National  
Infrastructure  
Planning  
Temple Quay House  
2 The Square  
Bristol BS1 6PN

Our Ref: EN070005

### **Application by Esso Petroleum Company Limited for an Order Granting Development Consent for the Southampton to London Pipeline Project**

#### **Advice following issue of decision to accept the application for Examination**

SPECIAL CATEGORY LAND PLAN - SHEET 109

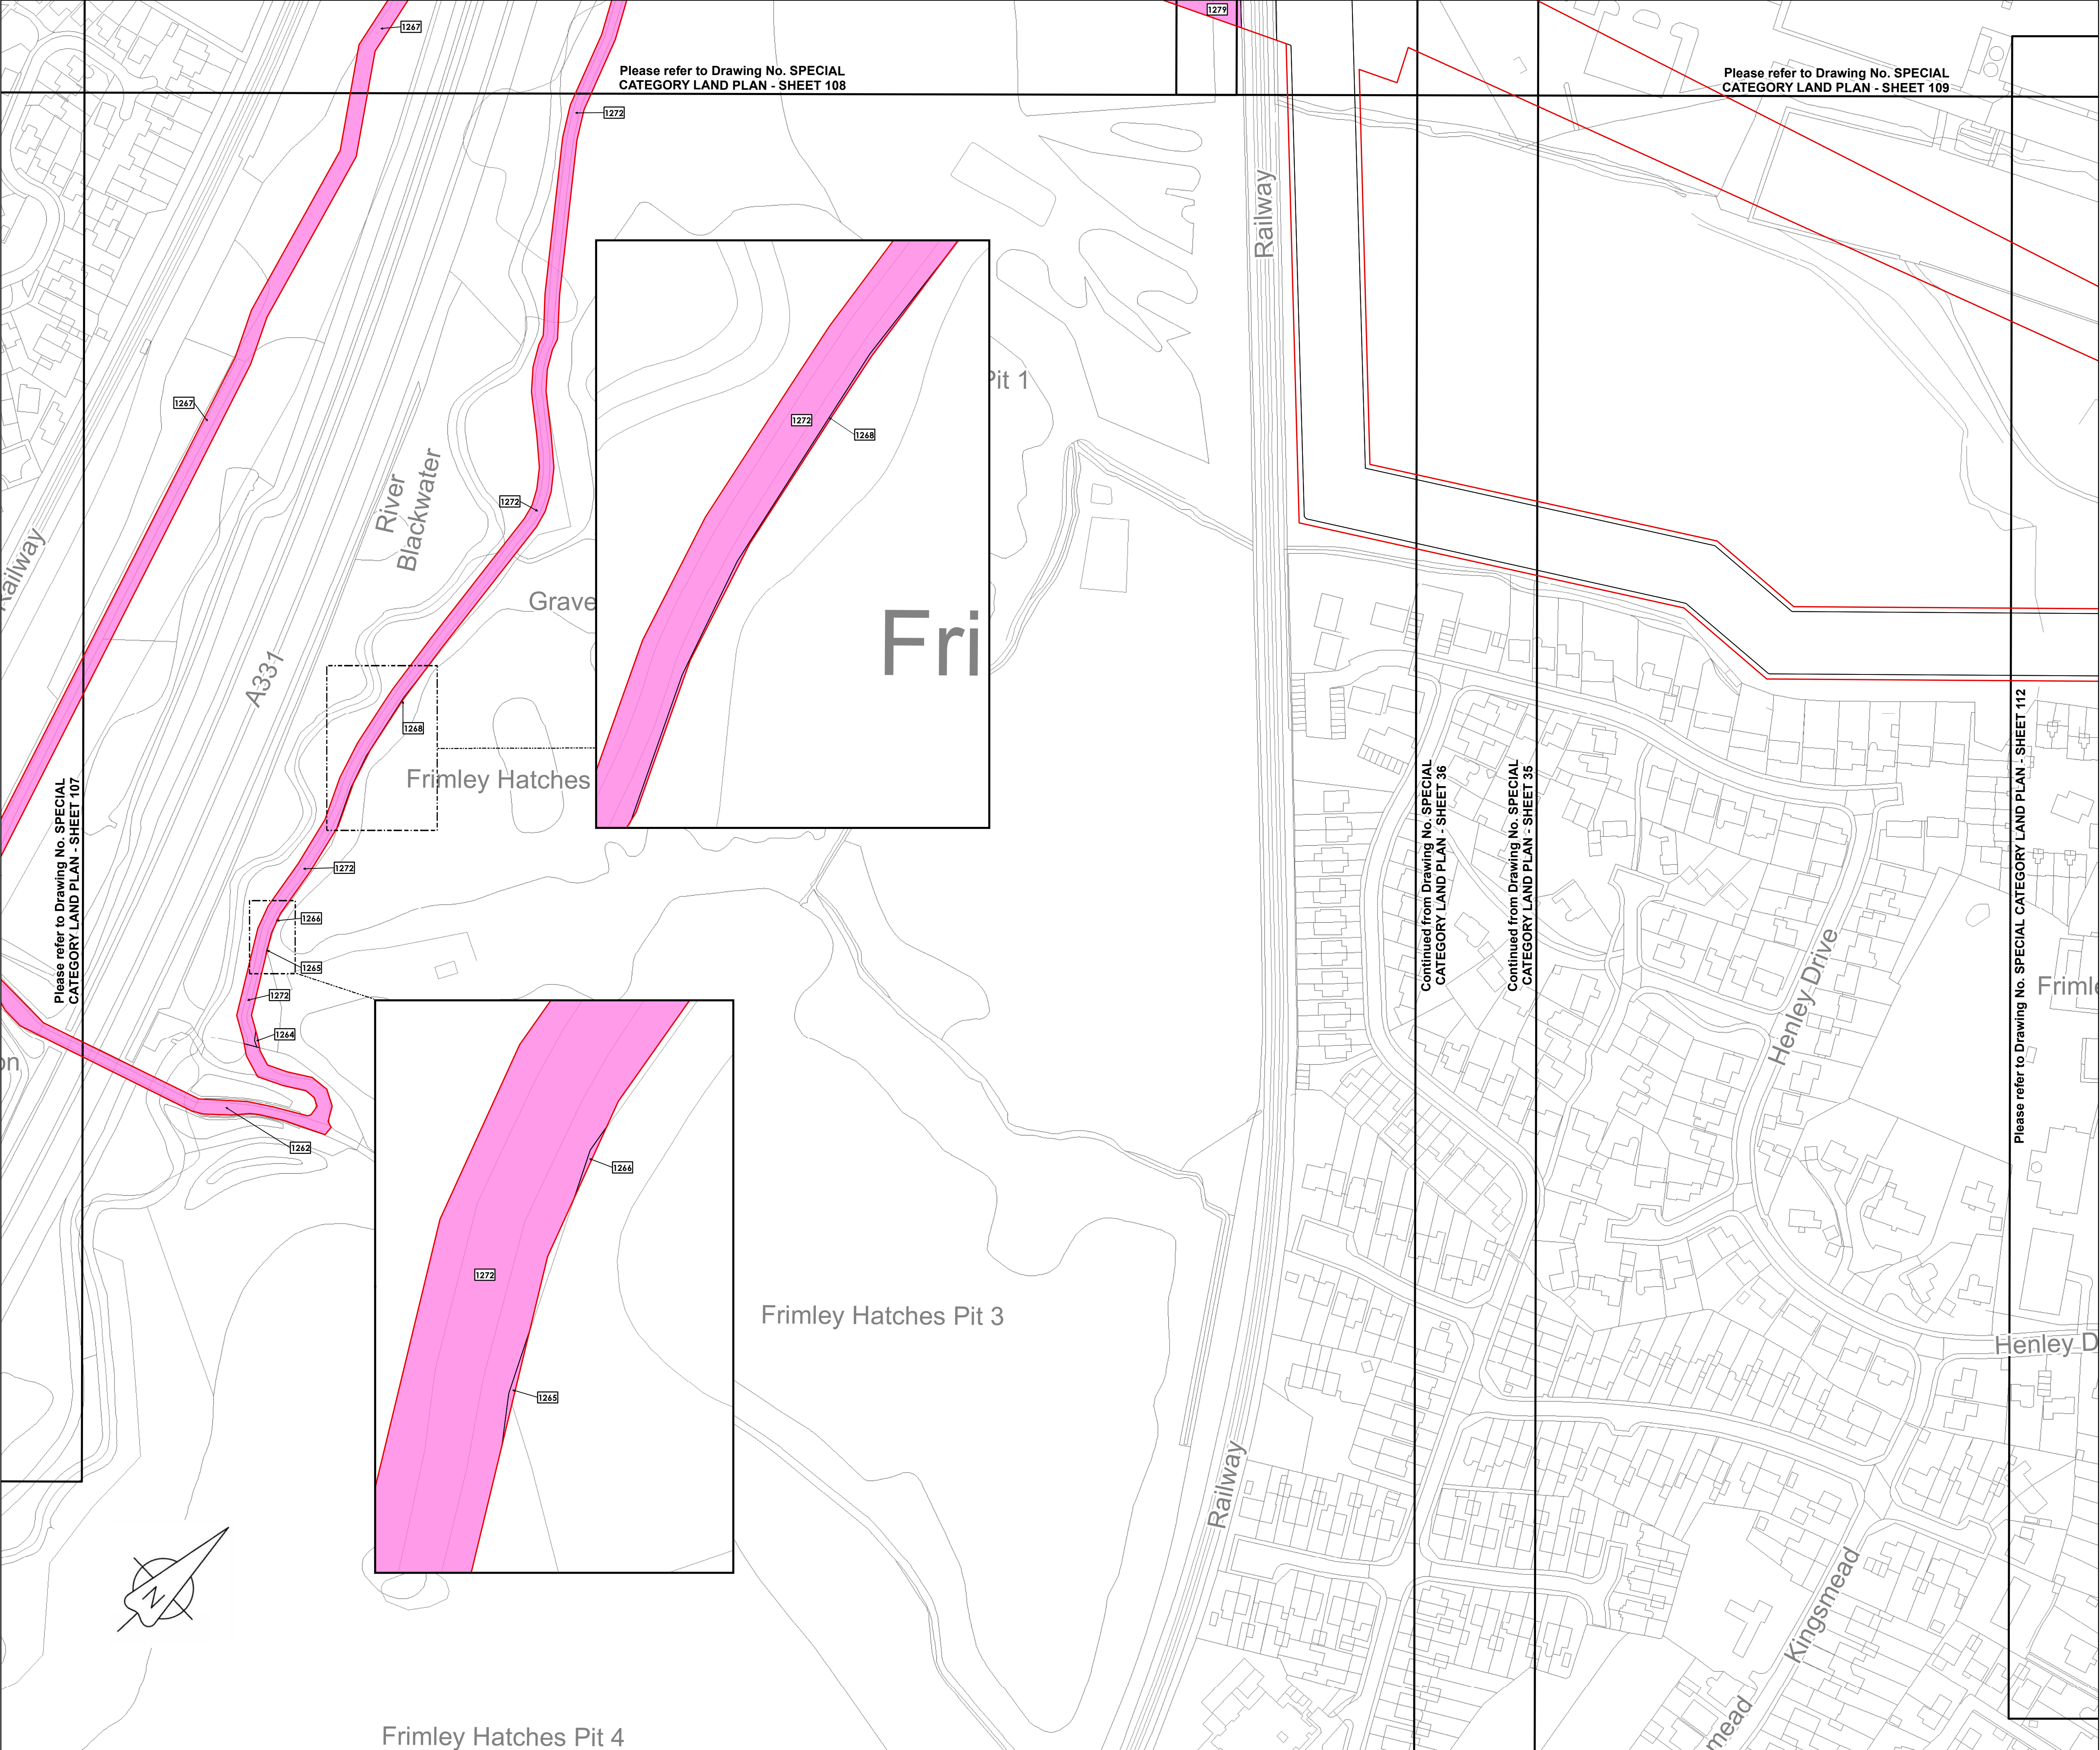
In some Works Plans there are plots which do not appear to have a use category/shading (for example sheet 109). The Applicant should review the Works Plans to ensure all use categories/shading are correctly identified.
